Application Reference: 2025/0571

Site Address: 434 Carlton Road, Carlton, Barnsley, S71 3HX

Introduction: Replacement of attached garage flat roof with dual pitched roof.

PROPOSED FRONT ELEVATION

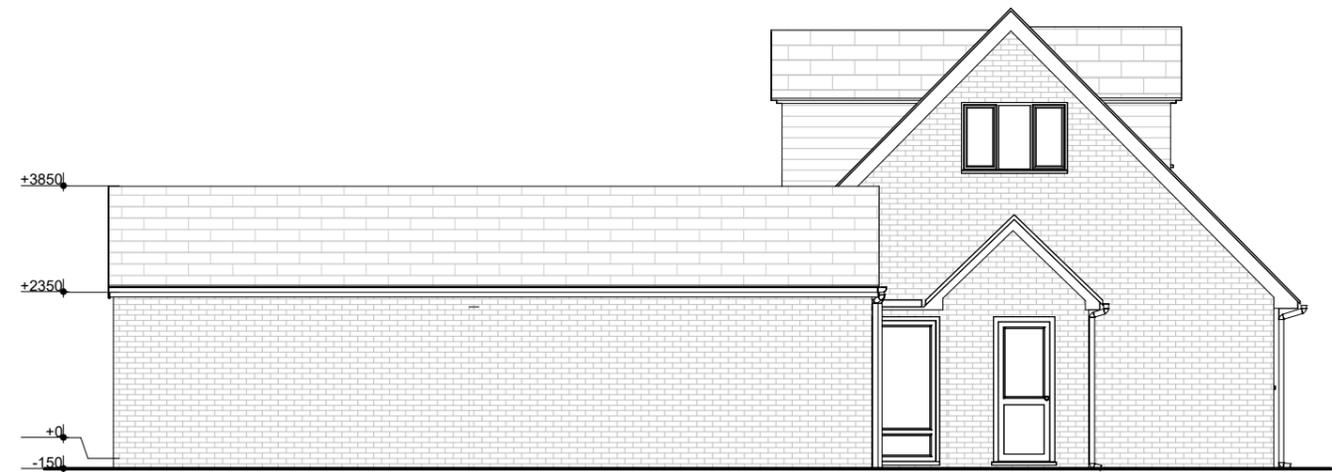
The proposal provides an eaves height of approximately 2.35 metres and a ridge height of approximately 3.85 metres which is permitted under the House Extension SPD. The proposed use of a pitched roof allows the garage to be more in keeping with the site dwelling than the existing flat roofed garage and is considered an improved roof form.

It has been necessary to make contact with the applicant requiring a reduction of the eaves and ridge height to meet the House Extensions SPD dimensions. Amendments were received.
